DOCUMENT SUBMITTAL
TO CITY PLANNING DEPARTMENT
DEVELOPMENT REVIEW BOARD CHAIR

Buffer Area Adjacent to Homeowner's Property and Planned Development

ENGINEER'S SEAL
RONALD R. BOHANNAN
NEW MEXICO
7868
PROFESSIONAL ENGINEER
7/31/2020

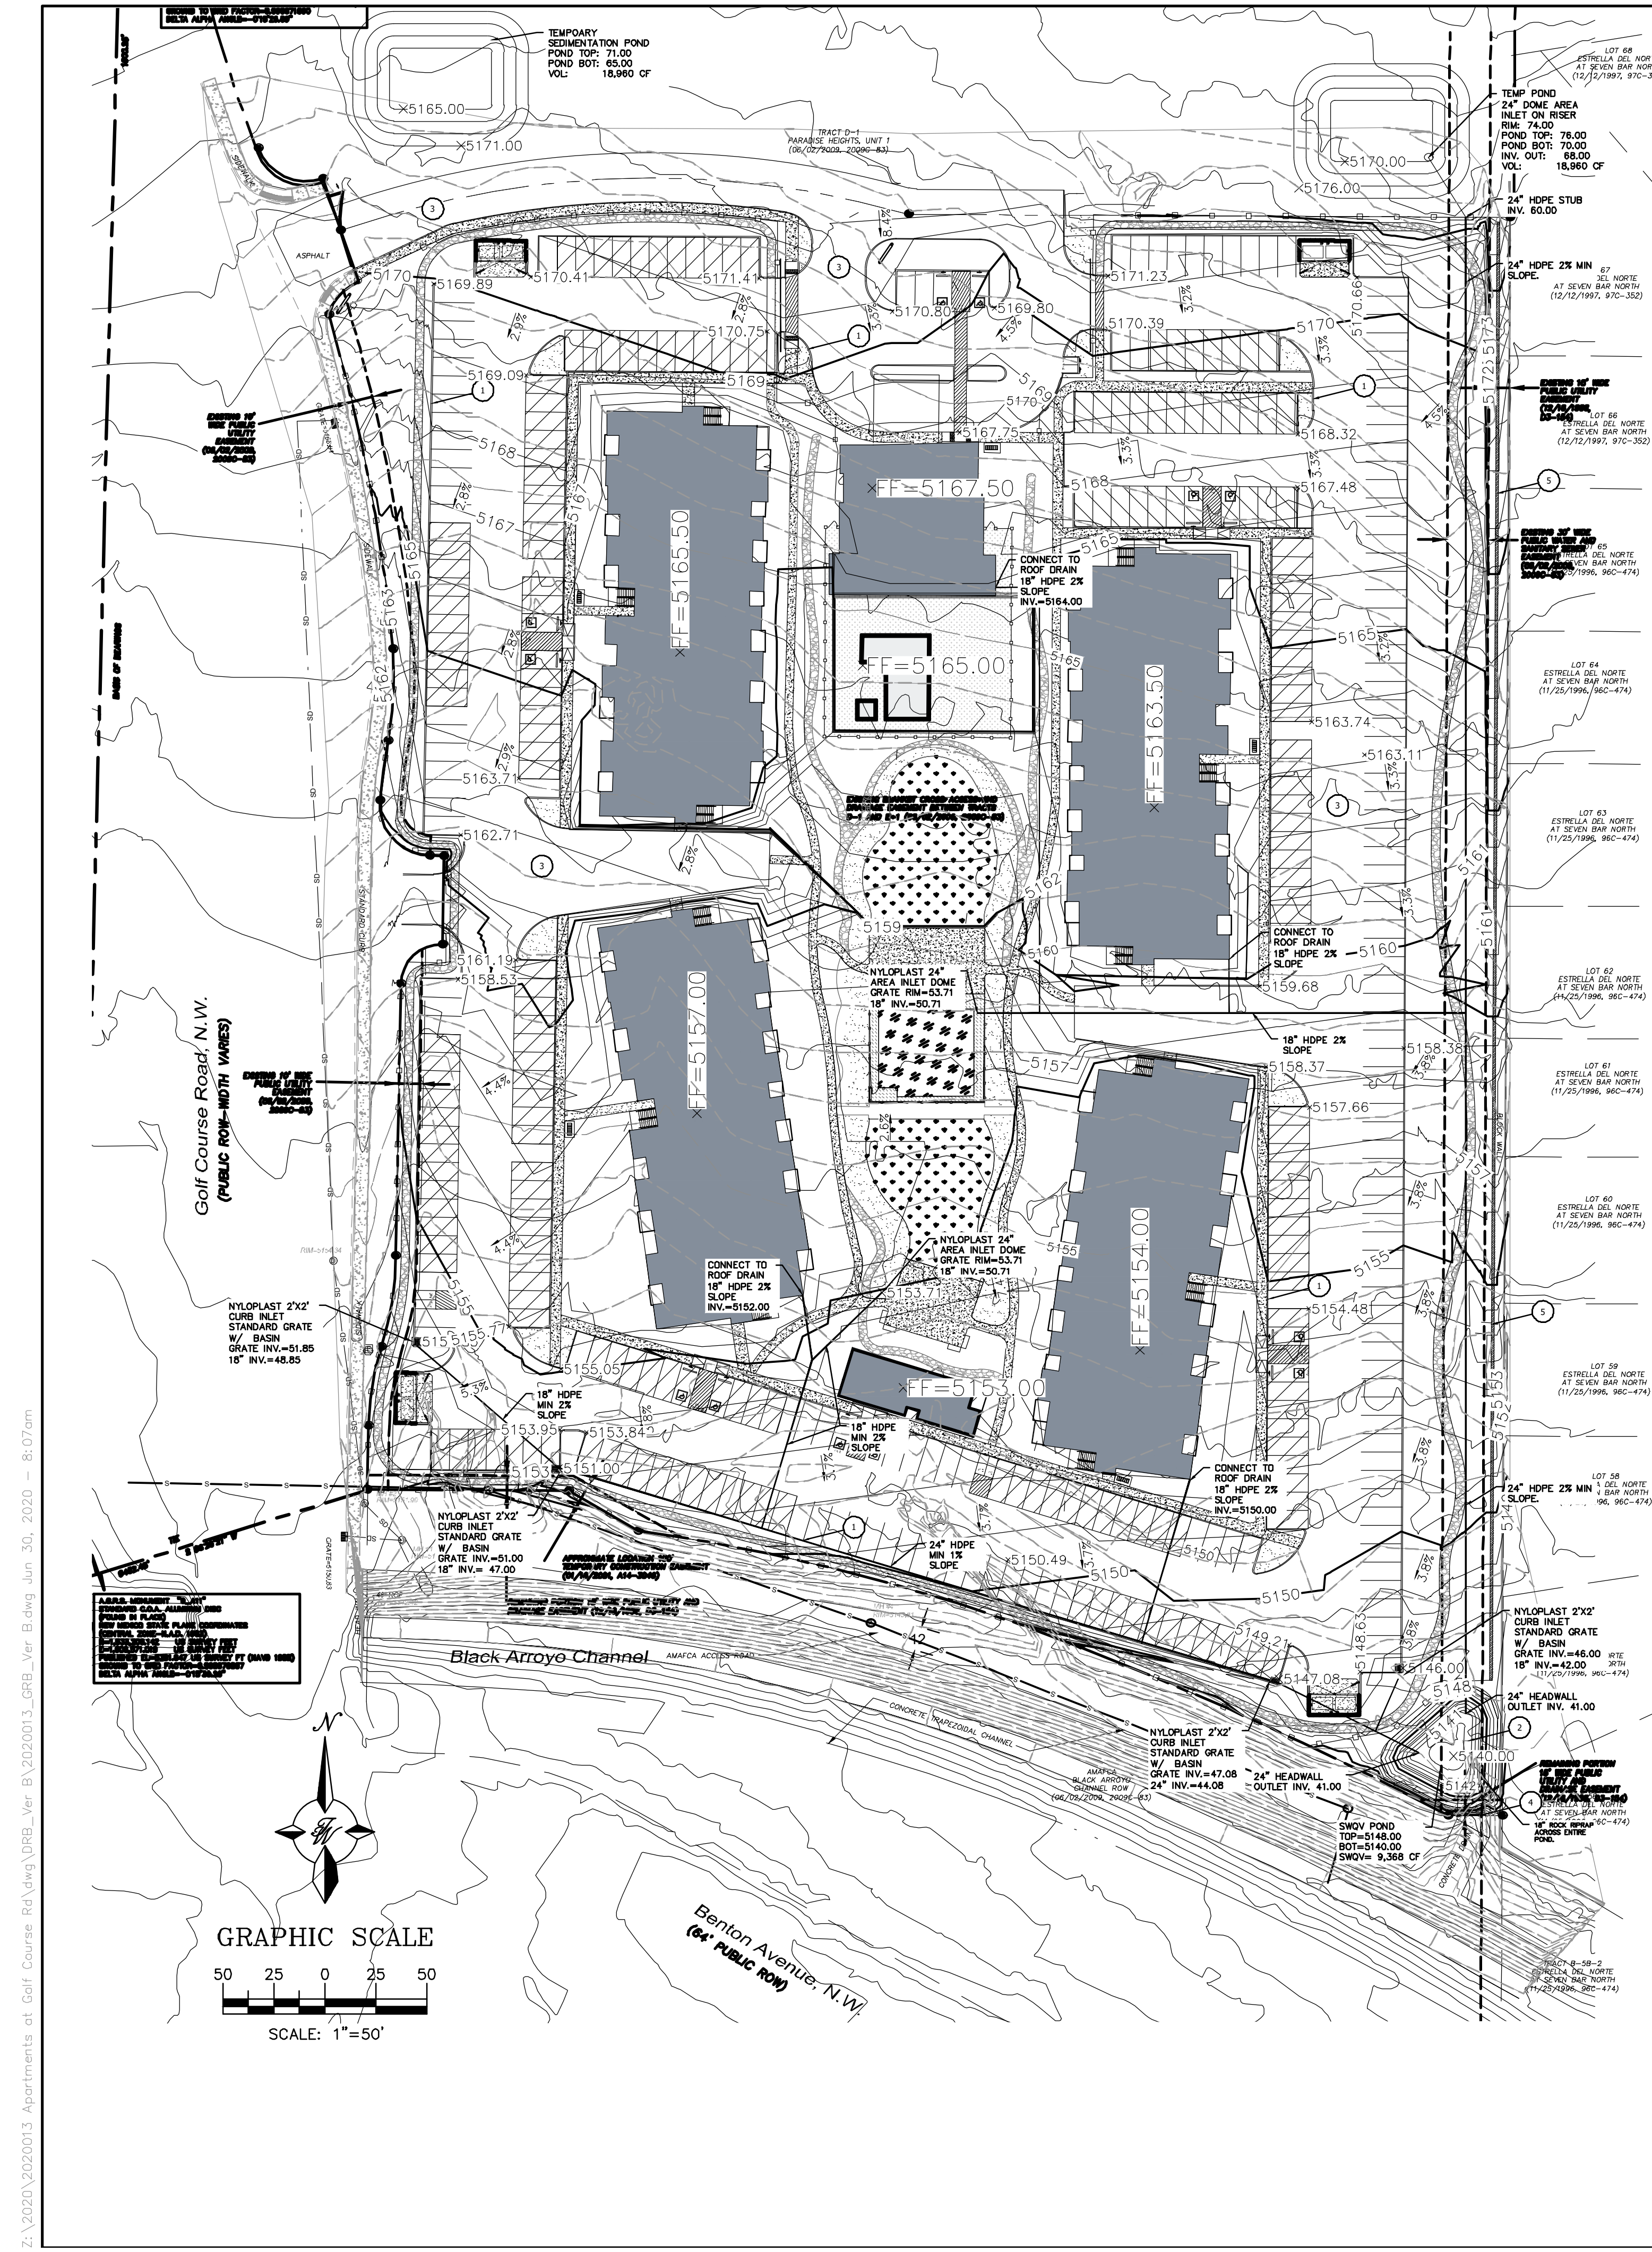
1. **The Buffer area:** We have asked that the buffer area be a true buffer area.
 - ✓ We have requested sound barriers, Line of sight barriers, fencing barriers, landscape barriers, lighting barriers.
 - ✓ We requested a sound and visibility wall at least 8 feet along the East end of the property boundary.
 - ✓ We have requested that the recreational walking trail adjacent our properties be removed.
 - ✓ We want to discourage foot traffic along our property line.
 - ✓ We have requested Large River walk as opposed to Grass to discourage foot traffic.

- ✓ We also would like the landscape plan to include more mature trees, to protect immediate privacy. The current plan has at least 10-year maturity
- ✓ We would like plants that do not affect allergies. Juniper plants are a major contributor to allergies.
- ✓ We want Trash Bins moved away from the East side of the development, away from homeowners' properties.
- ✓ Lighting must be directed away from private properties.
- ✓ We discourage Grass on the East side buffer, being that the noise generated by maintenance and mowing would impose on the neighborhood.
- ✓ Water runoff and drainage has not been addressed adequately to the neighborhood concerns.
